From: [Bryony Stala](#)
To: [Aquind Interconnector](#)
Cc: [Asim Kayani](#)
Subject: West Waterlooville Developments and Grainger Plc written representation and EXQ1 response
Date: 06 October 2020 11:41:56
Attachments: [West Waterlooville Developments and Grainger Plc Written Representations.....pdf](#)

AQUIND CONSULTATION – WEST WATERLOOVILLE DEVELOPMENTS/GRAINGER PLC

On behalf of West Waterlooville Developments and Grainger Plc, this letter provides Written Representations in relation to the land owned by West Waterlooville Developments and Grainger Plc and a response to the Examining Authority's First Written Questions (EXQ1).

TITLE: **Order Limits including Onshore Cable Corridor Section 4c**

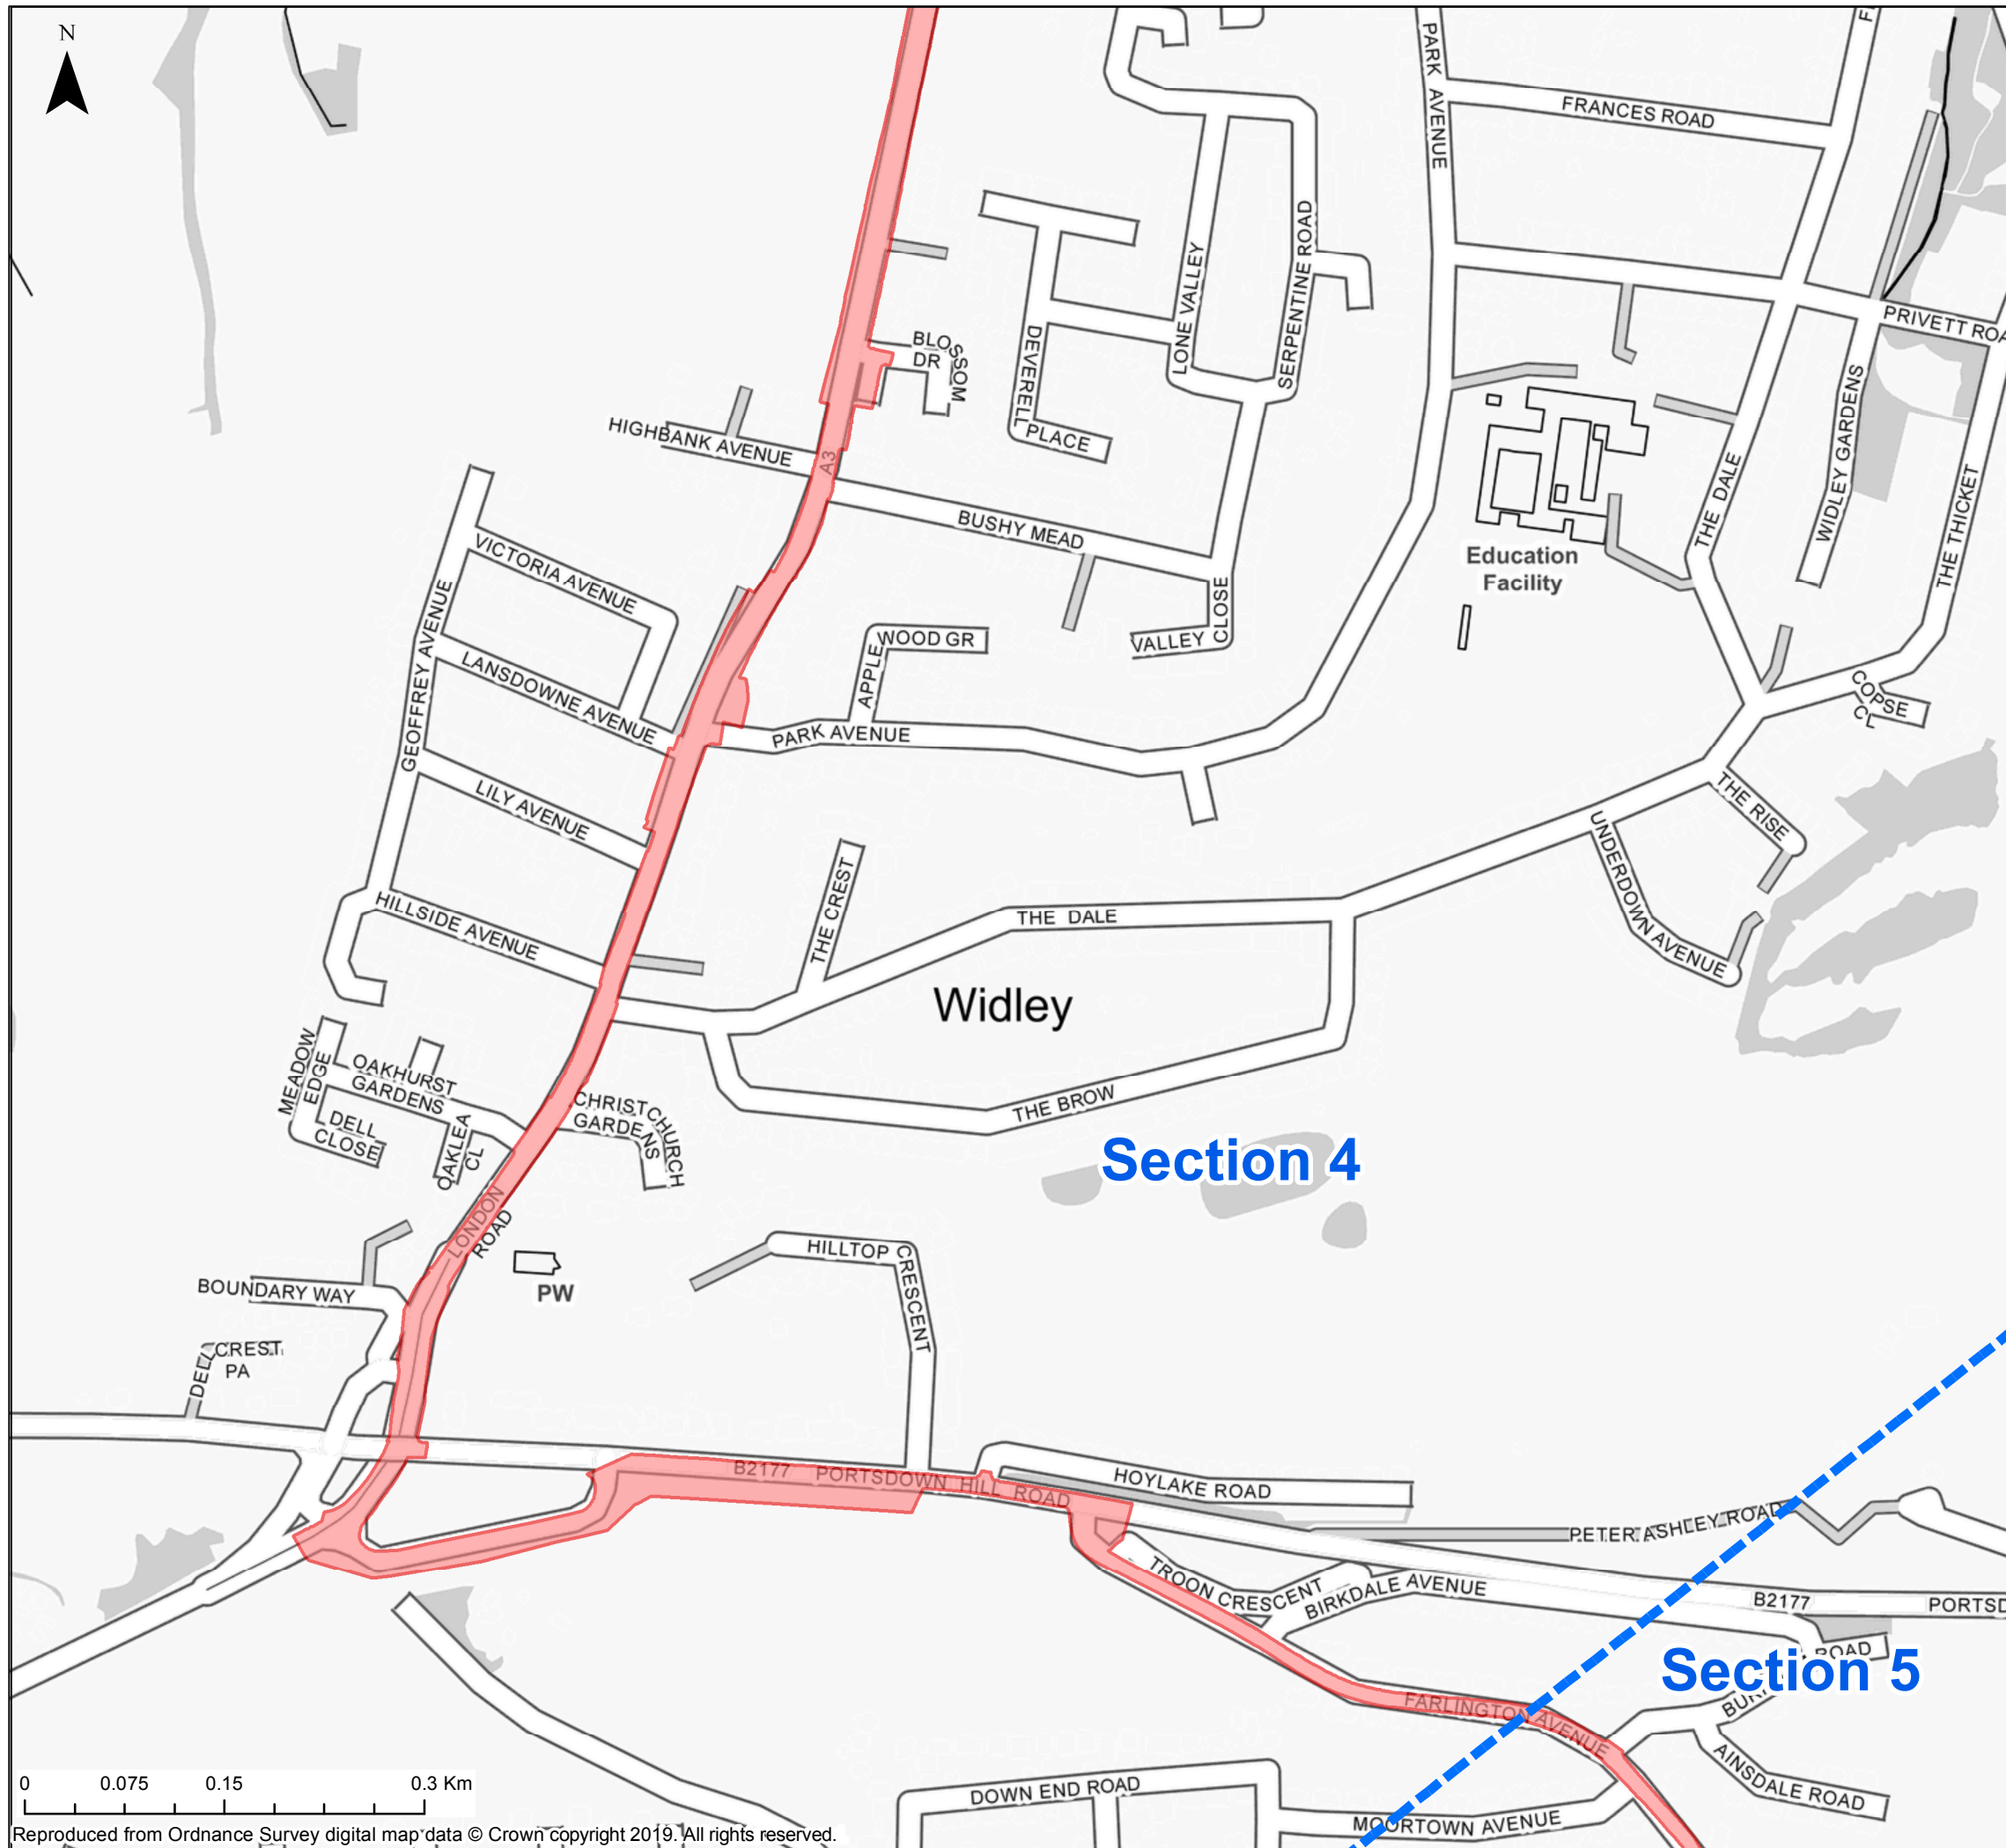
The Southern Access design is advanced, with S.278 approvals in the process of being finalised with Hampshire Highways and works due to commence in spring 2020. The timing of the laying of section 4c of the cable should be considered to prevent any disruption to the delivery of the southern access junction, which is imperative to meeting the requirements of the S106 and ensuring sufficient network capacity to accommodate the delivery rate of housing within the Berewood development.
